**Re: 926 Coal**  
**926 Coal Ave SW**  
**TCL**  
Architect's Stamp 1-3-24 (K13D085)

Based upon the information provided in your submittal received 1-4-24, the above referenced plan cannot be approved for Building Permit until the following comments are addressed:

1 SITE PLAN
SCALE: 1/8" = 1'-0"

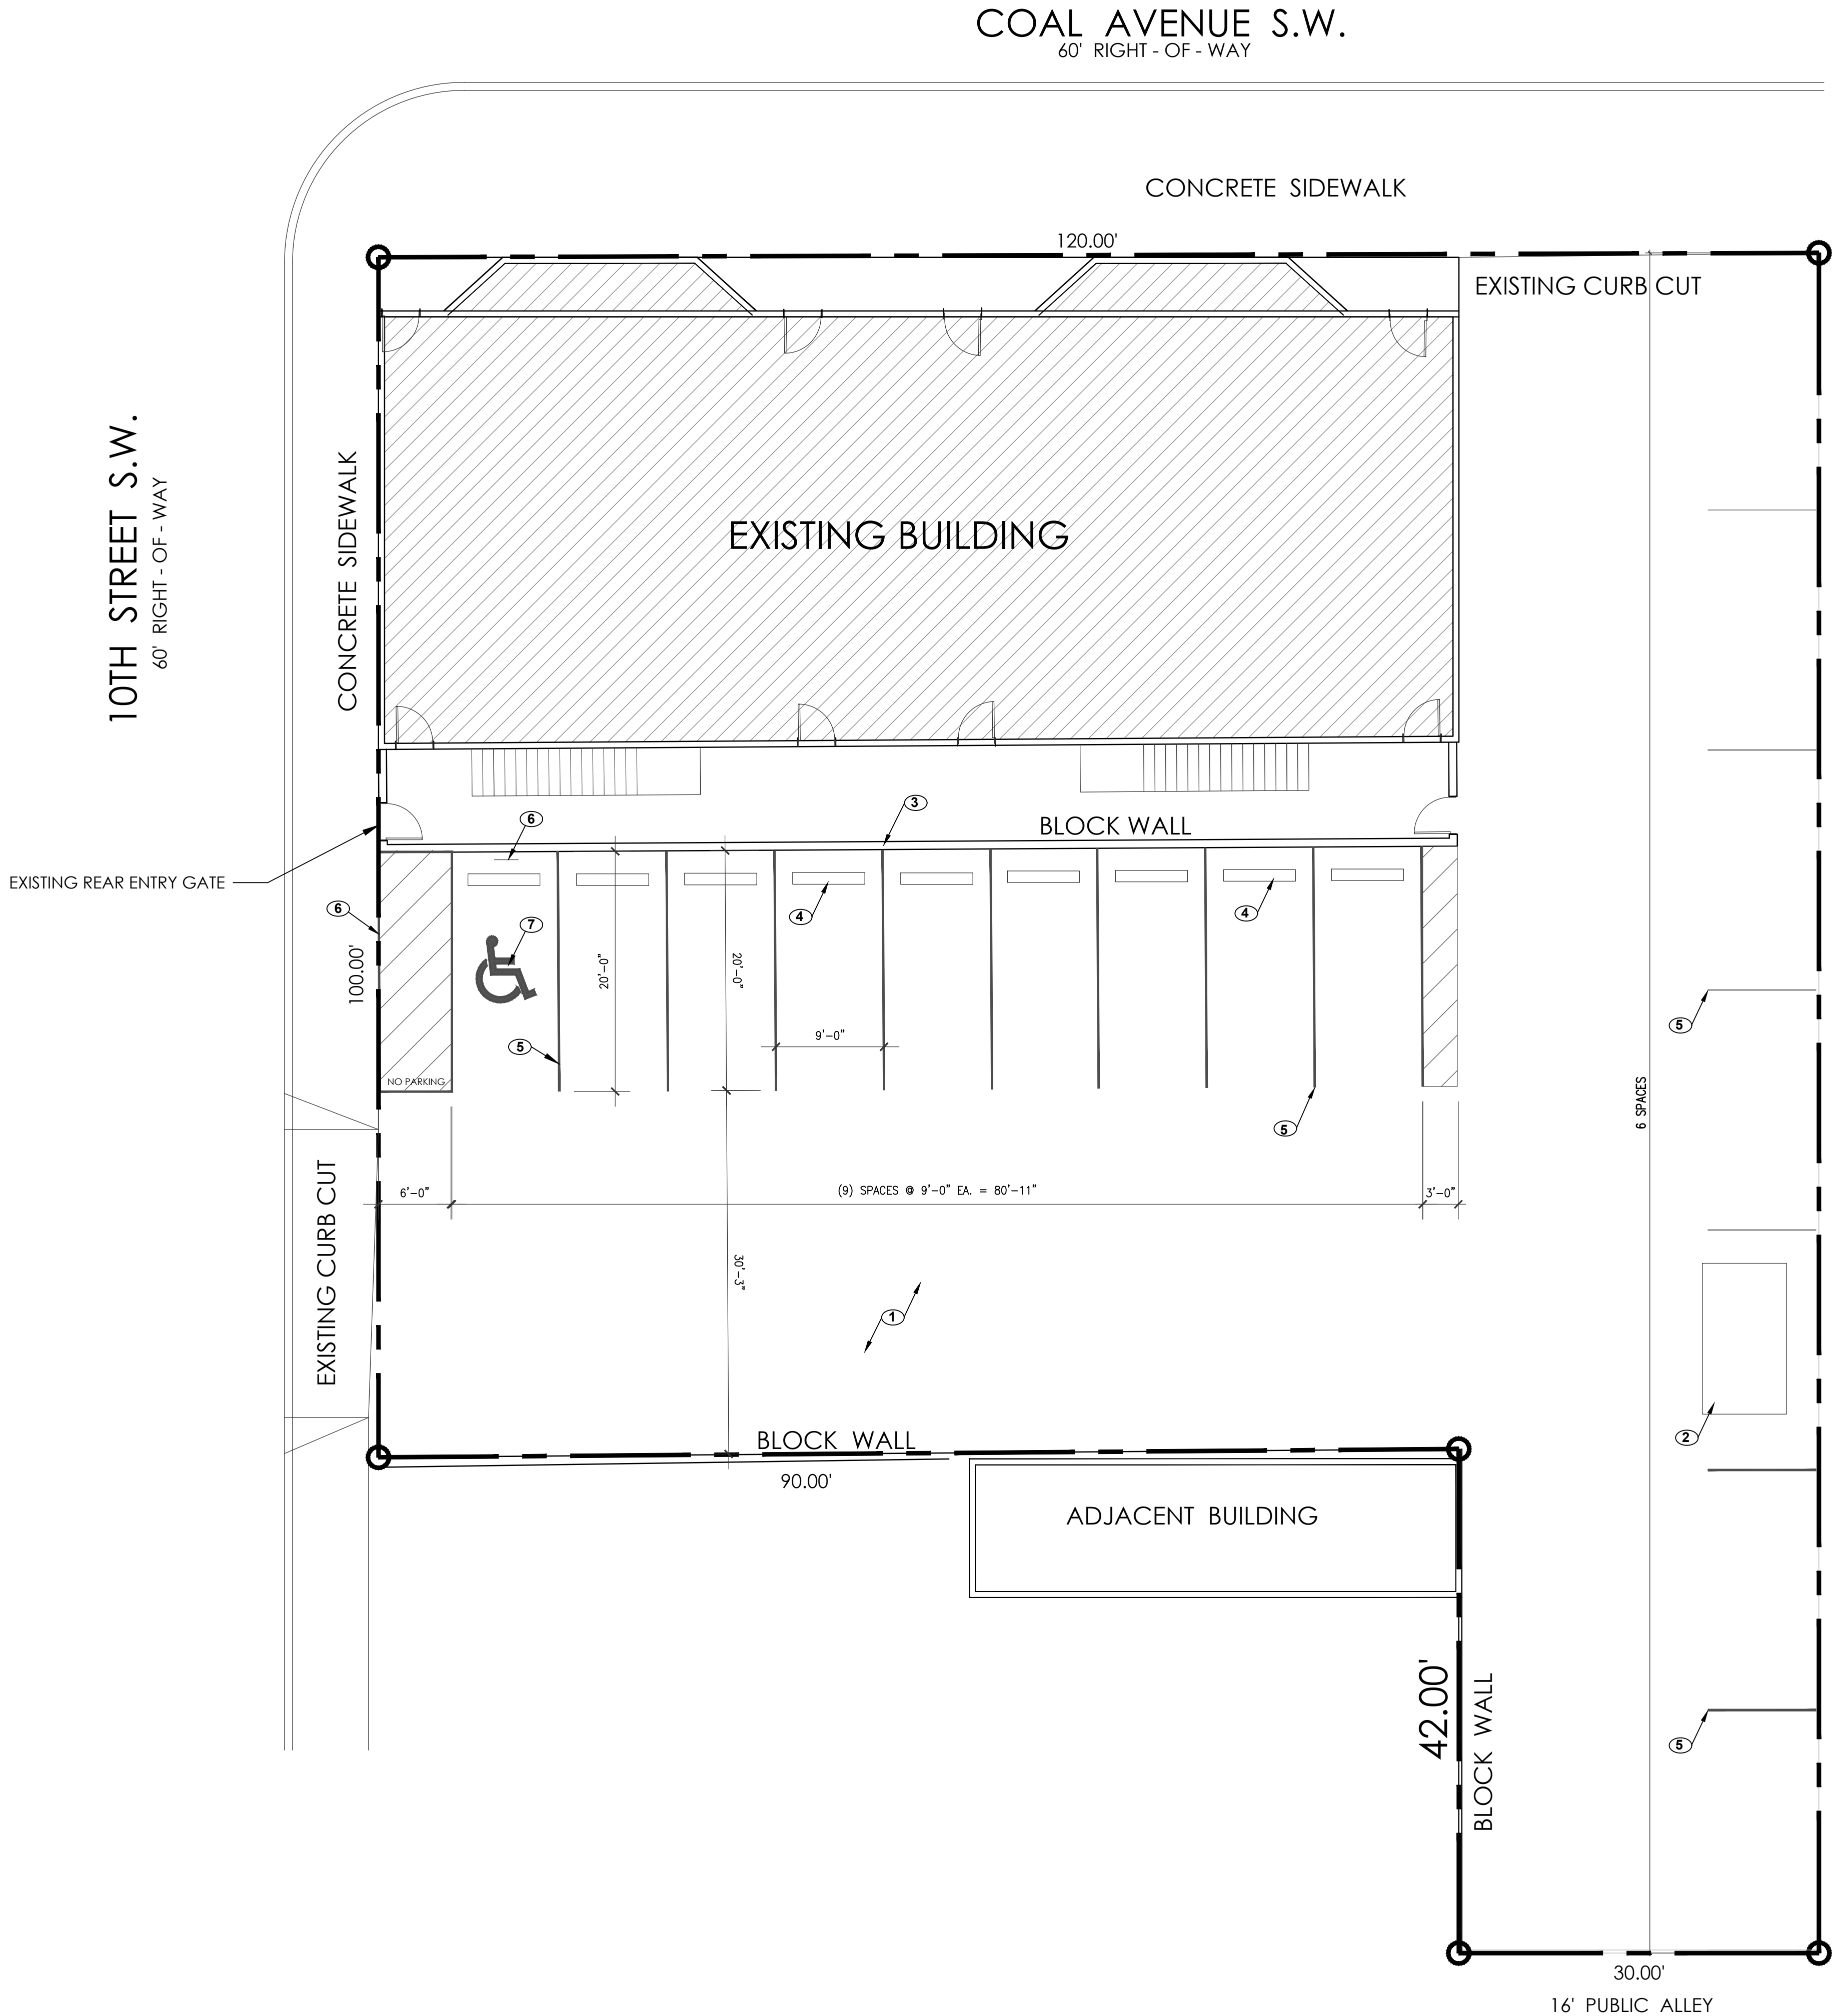
1. The plan is to include all existing conditions. A few of the omitted items are: drive through booth, bike rack, power poles and bollards along the south edge of the project. A site visit was performed on 1-9-24.

2. Required parking is dependent on use. Provide the use in the "Scope of Work" and revise the parking calculations accordingly. Include bicycle parking. The site is within 1,320 feet of premium transit, so there is a 30% reduction in required parking.

3. The van accessible aisle is to be 8 feet wide. There is a Keyed note 6 that most likely should be a Keyed note 8.
4. The pavement marking for the accessible parking space and the sign used are not quite correct. I have attached da couple images to the email that will help with the sign and the pavement markings for the accessible parking and aisle.

5. There is not enough room for parking and a 2-way drive aisle. There is 23' from the drive-up window to the pipe rail and 26' form the curb to the pipe rail. Show the pipe rail and the curb on the plan.

6. Remove the south parking space near the alley. The alley is blocked by a fence (not shown on plan, but should be) and there is not enough room to park in this space.

7. Show the drive-up sign. Will it be removed? If so, include a keyed note.
8. Show the bollards on the plan that protect the house and the wall. Some are missing and some are damaged. Provide new bollards where they are missing, replace the

bollards that are leaning over/not structurally sound and repaint the ones that are structurally sound.

9. There are 4 or 5 broken sidewalk stones on 10<sup>th</sup> st beginning at the drive entrance that are to be replaced. Add a Keyed Note.
10. In addition, to #9 above, when the stone is replaced at the north end of the drive entrance, the longitudinal sidewalk slope is to be reduced so it is less than 8.3%, 7.0% preferred.

11. Along 10st there are a couple roof drains that are to be addressed:
  - a. The one that is on top of the pony wall cannot drain onto the sidewalk especially not at a waist/chest height.

- b. There is another roof drain, north of the one mentioned above, that is tucked between the sidewalk and the building. This will drain over the sidewalk. IT is to be rerouted or can drain through a sidewalk culvert. Sidewalk culvert approval is done through our Hydrology Section.

12. The trees next to the building along 10<sup>th</sup> street are to be trimmed back so they don't overhang the sidewalk or be removed.
13. The trash and debris on the sidewalk on 10<sup>th</sup> st are to be removed. Any cracked/damaged sidewalk in this area is to be replaced.

14. The supports for the awning and swamp cooler along 10<sup>th</sup> street are lower than 7 feet over the sidewalk and are over the City's ROW. The minimum clear height above the sidewalk is 7 feet. If this minimum height is obtained, a Revocable Permit is required if they remain over the City's ROW. The plan should indicate what is to occur.

15. Add a detectable warning surface to the ramp on the project's NW corner (10<sup>th</sup> and Coal).
